From: Melissa Schumaier
Sent: Wednesday, October 8, 2025 9:37 AM
To: Mau, Russell E (DOH); Ellie Myers
Subject: RE: SD-25-00001 Easton Research and Rearing Facility Outfall - Notice of Application

The Department of Health (DOH) Office of Drinking Water (ODW) has reviewed the application and has the following official comments:

Subject: SD-25-00001 Easton Research and Rearing Facility Outfall - Notice of Application

CS101

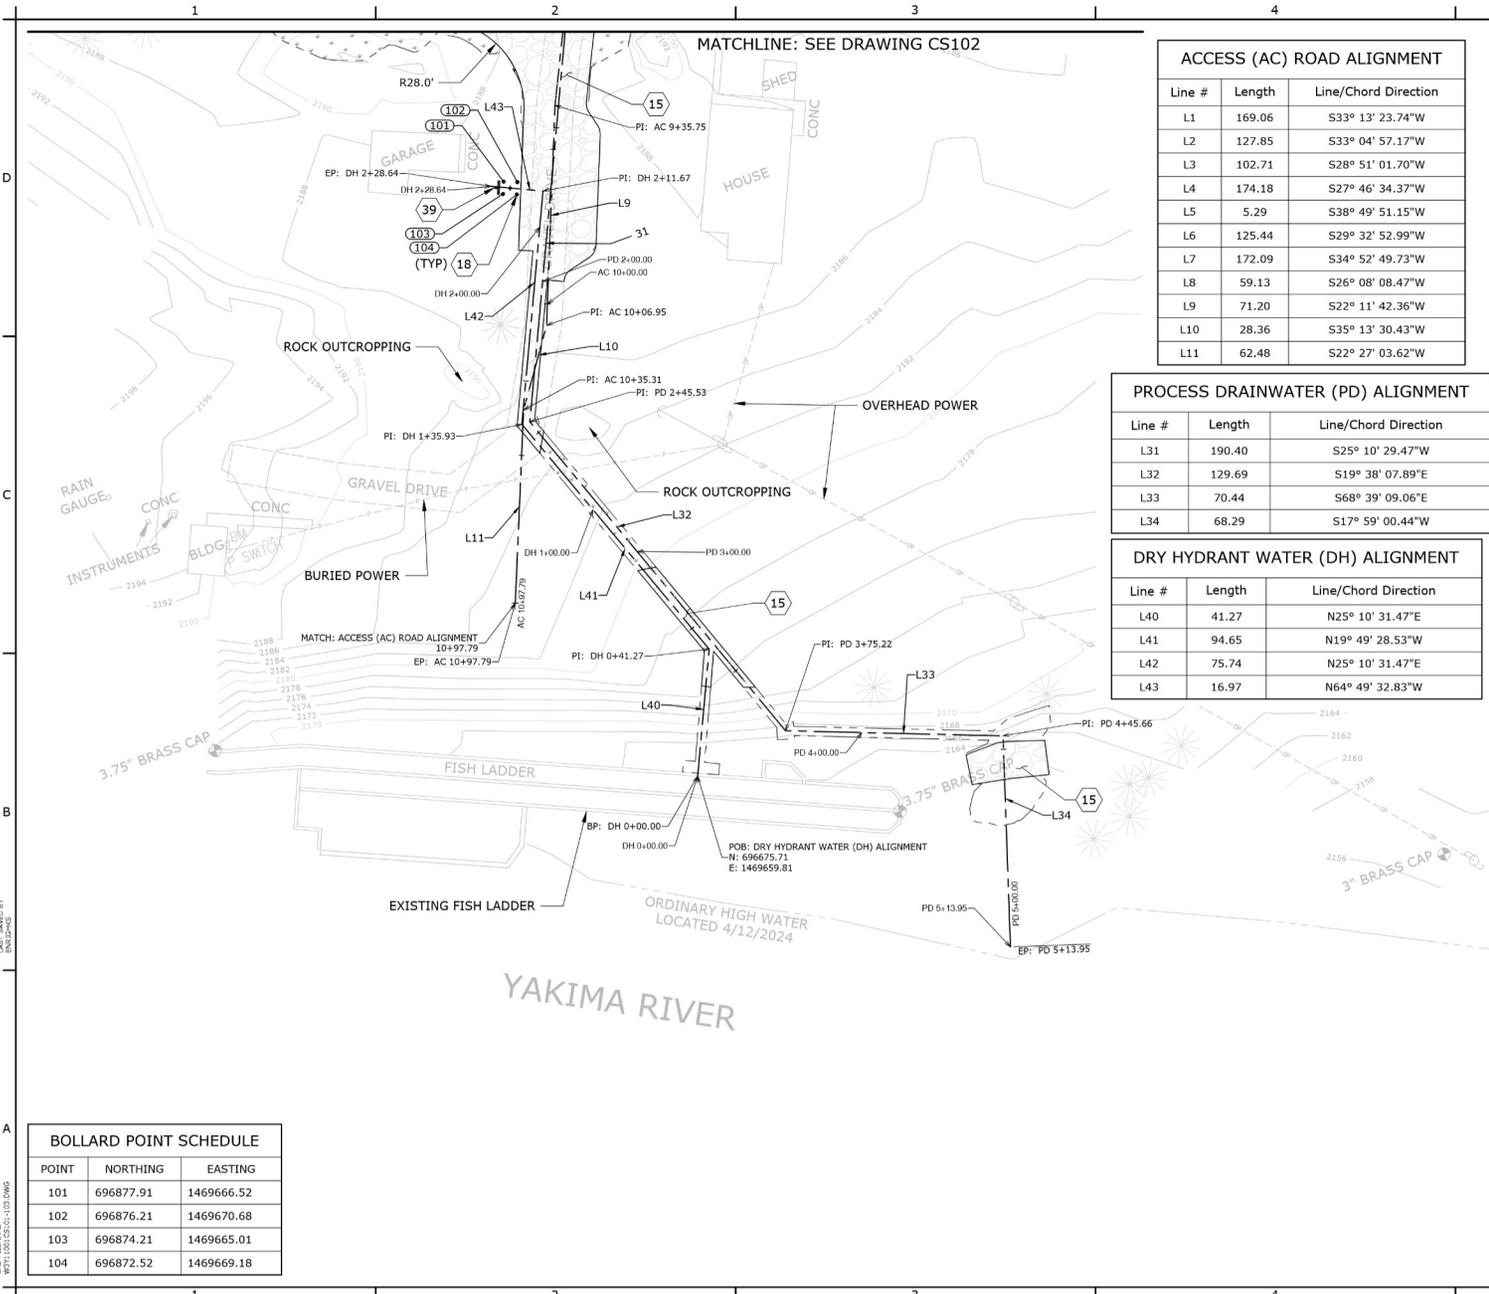
1. The applicant proposes a new groundwater well to provide water, for “drinking” water uses, within the proposed building – DOH ODW seeks the following information:
 - Is the proposed property within the service area of the “Easton Water District” (ID #42700)?
 - What is the number of persons who will be on-site per day and per month?

I have already been in contact with the individuals in charge of this project. If they choose to use another well with Lake Easton State Park, then they will reach out to get that source approved if it can be. Otherwise, they are looking into connecting into Lake Easton "East" well.

Russell, this is the connection that I was referring to when I send over the tag number for the existing well that we didn't have any information for inside the Lake Easton State Park. That initial well isn't usable yet. I am so sorry you reviewed something that was already in progress.
